Application for a non-material amendment following a grant of planning permission.

Proposed workshop/store/garage

H06-0579-18

Project PROPOSED WORKSHOP / STORE / GARAGE, CARDWELL HOUSE, DANSMEARE ROAD, DANSMEARE, LINGS, PE12 9NQ.	
Client MR & MRS R SWAN,	
Drawing PART SITE PLAN PART BLOCK PLAN LOCATION PLAN	
H06-0579-18	Drawing No. 03

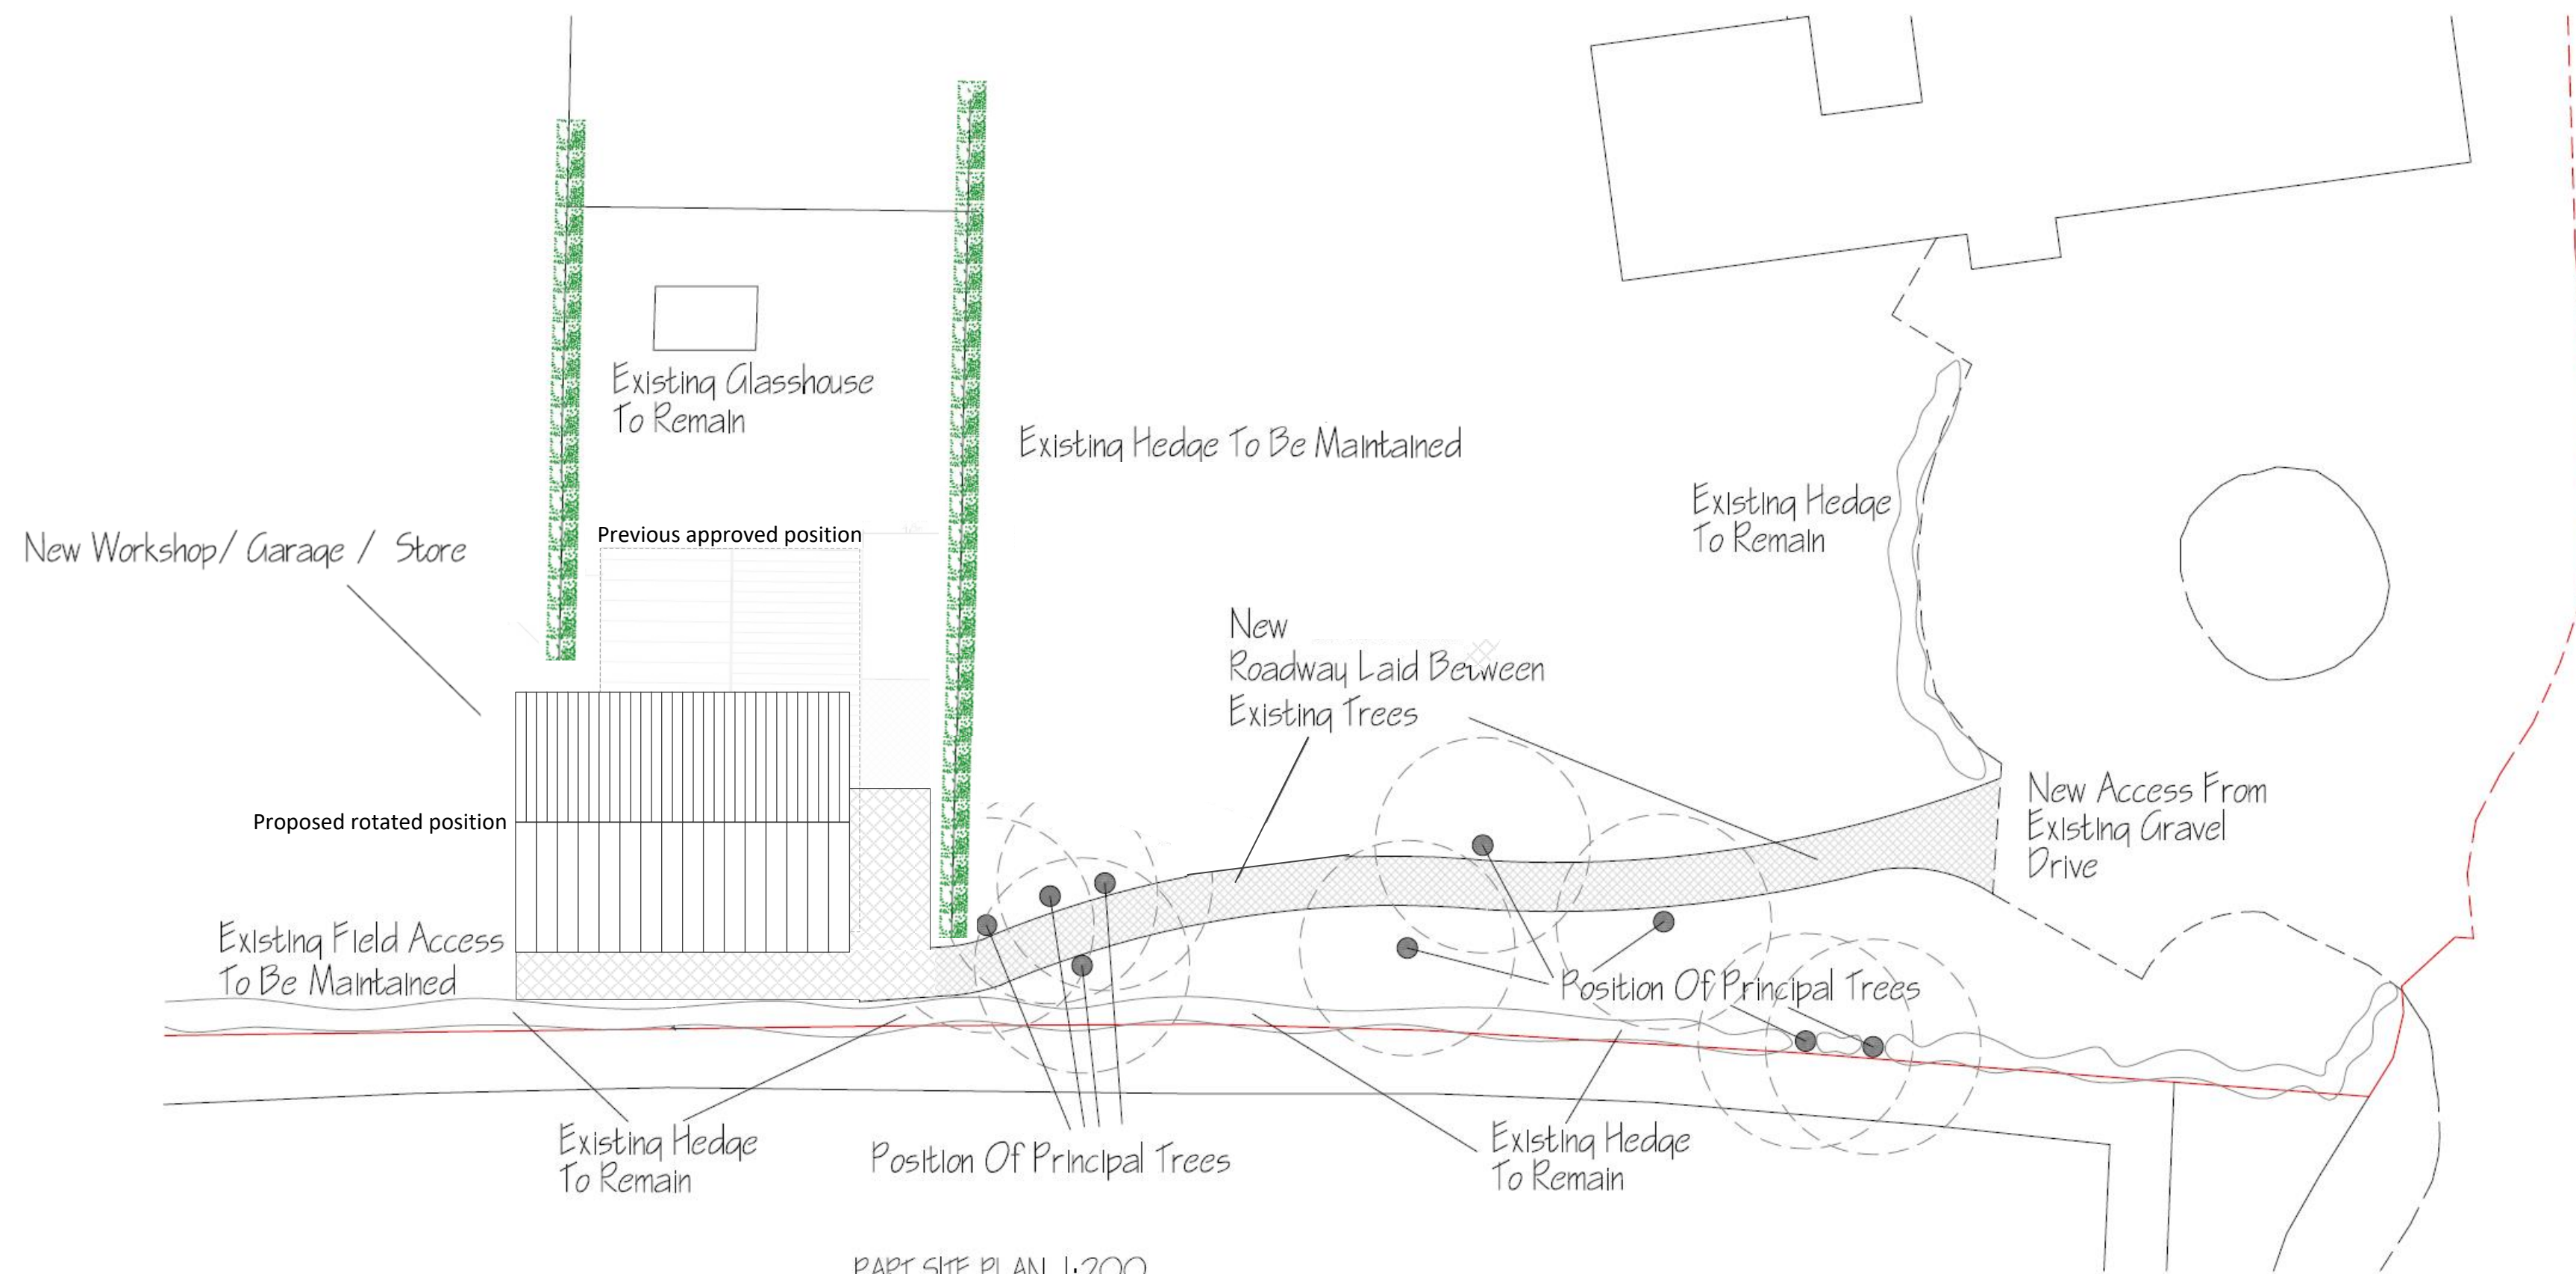
Change orientation of building.

Rotate building by 90° to change roof line from North/South to East/West

To provide south facing roof to enable solar panels to be fitted facing most effective direction should they be required at a future date.
